Advice on Environmental Impact Statement – State Significant Development

Proposal: Residential Flat Building at 64-66 Lavender St & 3-7 Middlemiss St, Lavender Bay

Major Project reference: SSD-86797708

Attachment A – Detailed Environmental Heritage Advice

SECTION A

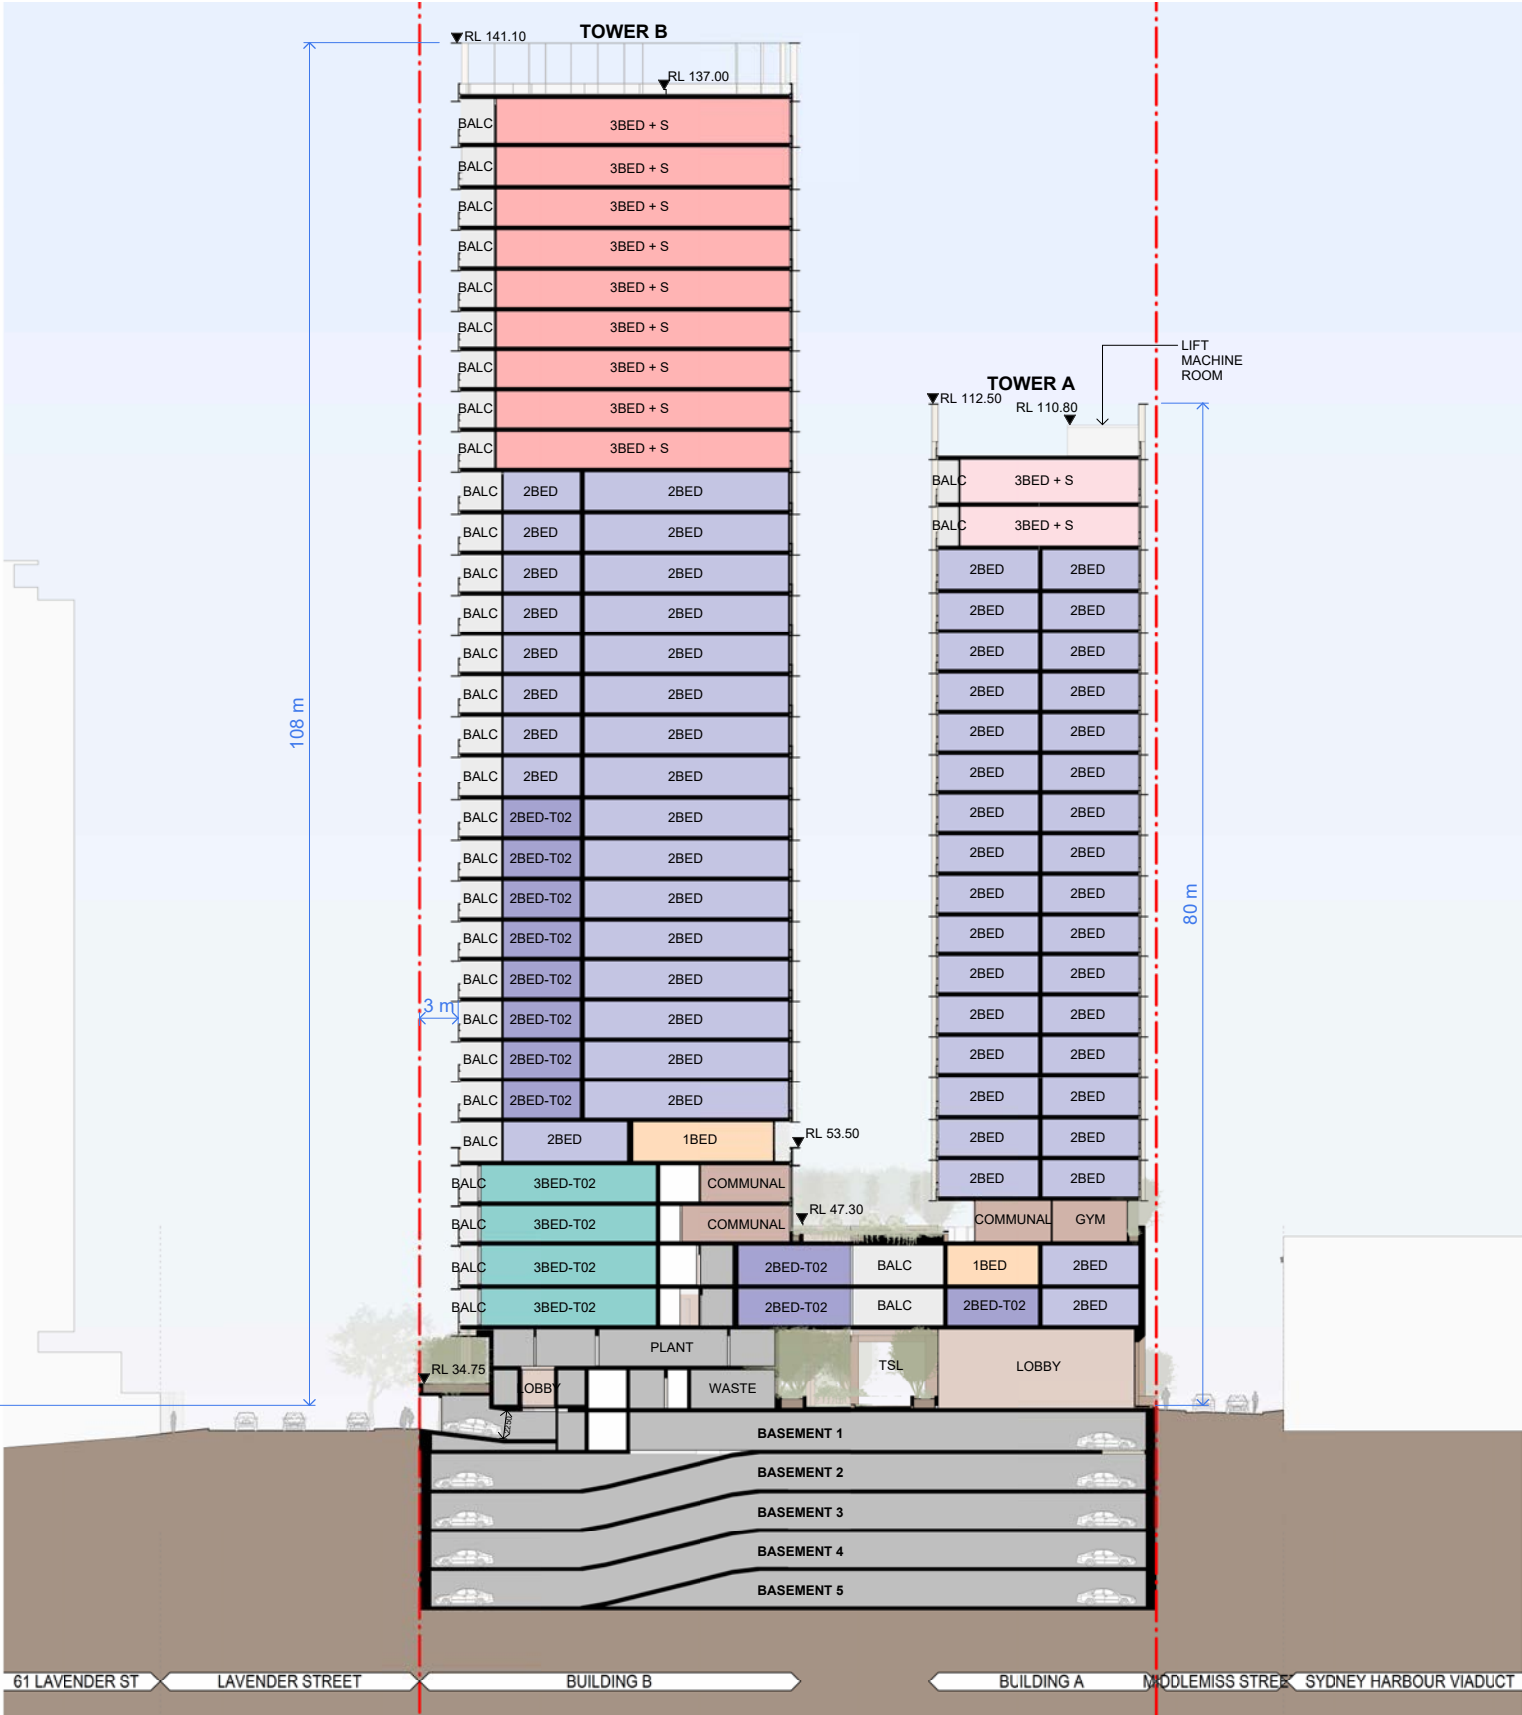
- Impact of the SSD on the Sydney Harbour Bridge Northern Approach:
 - Tower A would be located approximately 10 metres from the bridge's northern approach structure, separated only by the narrow width of Middlemiss Street. We consider that the 23-storey tower in such proximity would visually dominate the adjacent bridge approach, diminishing its significance.

We note that part of Milson's Point is characterised by high-rise structures, but Bradfield Park provides a buffer zone between these buildings and the bridge approach so that it retains its prominence. The width of Middlemiss Street is insufficient as a buffer between the 23 storey Tower A and the bridge approach.

- Tower A's substantial 40 metre width would block the existing sweeping views across the suburb of Lavender Bay, particularly when viewed from trains on the northern approach. These views, although not identified as key views in the Sydney Harbour Bridge Conservation Management Plan, nevertheless form part of the experience of travelling across the Sydney Harbour Bridge. Together with Tower B, expansive Lavender Bay views from the train would be severely impacted.
